# Comment for planning application 24/00539/F

<b>Application Number</b>	<input type="text" value="24/00539/F"/>
<b>Location</b>	<input type="text" value="Land To The East Of Stratfield Brake And West Of Oxford Parkway Railway Station Oxford Road Kidlington"/>
<b>Proposal</b>	<input type="text" value="Erection of a stadium (Use Class F2) with flexible commercial and community facilities and uses including for conferences, exhibitions, education, and other events, club shop, public restaurant, bar, health and wellbeing facility/clinic, and gym (Use Class E/Sui Generis), hotel (Use Class C1), external concourse/fan-zone, car and cycle parking, access and highway works, utilities, public realm, landscaping and all associated and ancillary works and structures"/>
<b>Case Officer</b>	<input type="text" value="Laura Bell"/>
<b>Organisation Name</b>	<input type="text" value=""/>
<b>Address</b>	<input type="text" value=""/>
<b>Type of Comment</b>	<input type="text" value="Objection"/>

Figure 7.2: Southeast Drainage Ditches HADDMS

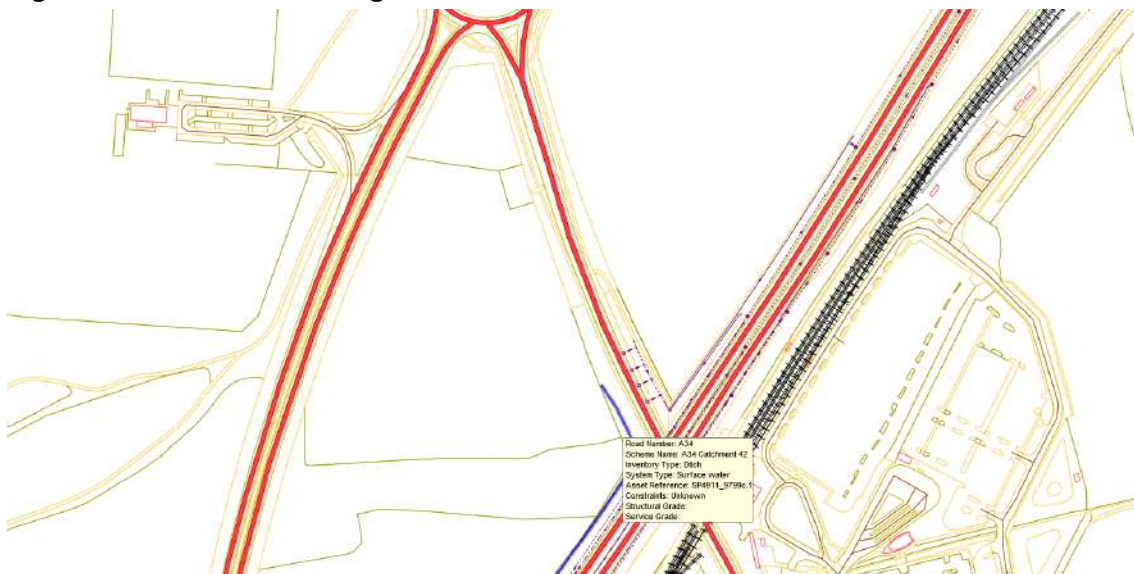
2) The discharge of surface water is dependent on a large diameter culvert under Frieze Way which is significantly blocked. Before a consent is granted OUFC need to demonstrate that there is an unobstructed route to a suitable watercourse able not only to accommodate the correct greenfield run-off rate from the development but also able to manage the increased volume of water that enters the watercourse in a much shorter period than is likely to be the case with the existing greenfield site. OUFC need to demonstrate that there surface water discharge will not increase downstream flooding to third parties. This will require more detailed studies and consultations to prove there is an outfall to the receiving watercourse.

3) OUFC surface water strategy assumes that the large diameter culvert will be cleared out by the landowner and future maintenance will be undertaken by them. As OUFC have no direct control of the culvert they cannot rely on either the culvert being cleared out and in particular that future maintenance will be carried out.

4) Correspondence with OCC Highways indicates that the existing large diameter culvert under Frieze Way may be a highway asset. By normal convention a highway asset will not be able to receive surface water discharges from a private development site. This is alluded to by OCC in that they have suggested a new culvert would be required under Frieze Way into a suitable downstream watercourse. OUFC have therefore not demonstrated that there surface water drainage proposals have a viable outfall. Before any planning consent is provided OUFC need to demonstrate there is a technical solution to convey surface water from there site to a suitable watercourse within land that they have control over. If the delivery of their outfall requires consent from another land owner then OUFC must provide details of the land owners consent. Without the said consent the application should be rejected.

6) The Mott McDonald report acknowledges there is some uncertainty about the viability of a culvert under Frieze Way being suitable for the site discharge. They have discussed an alternative strategy which seems to rely on using Highways England highway drainage. This strategy would not work as Highways England would not agree to receive a discharge of surface water from a private drainage system.

Figure 8.1: Proposed Catchment Areas

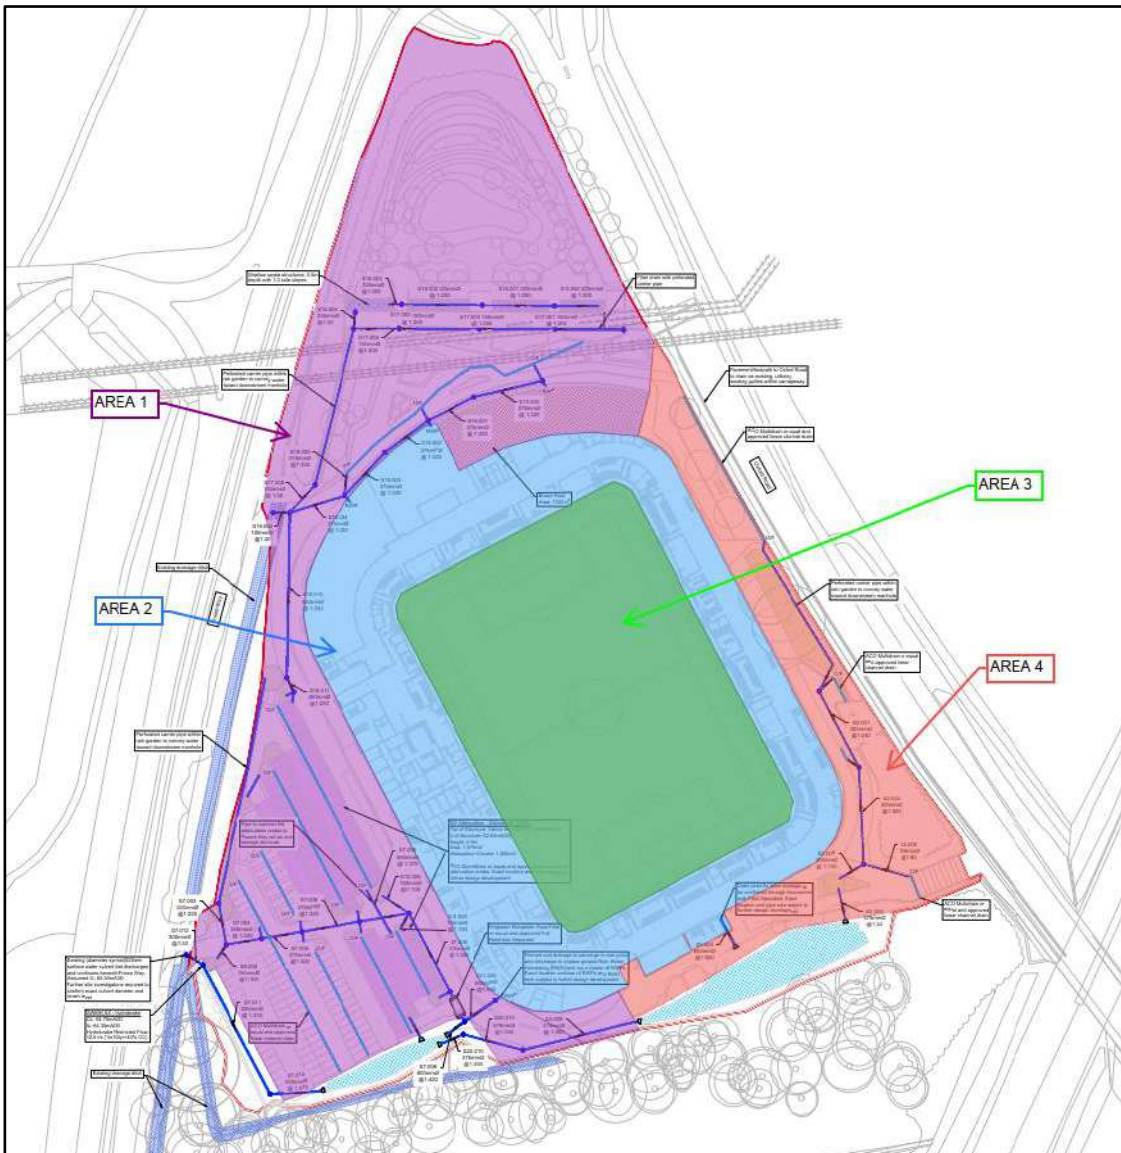
5) Whilst OUFC have considered the circumstances when the hydro-brake is blocked, this would only be a temporary problem until the hydro-brake is cleared or replaced. Being unable to discharge water from the site due to the culvert being blocked could be a much longer term problem. Water overflowing onto the car park and roads for anything other than a very short period would not be acceptable particular if the parking areas are used for disabled parking.
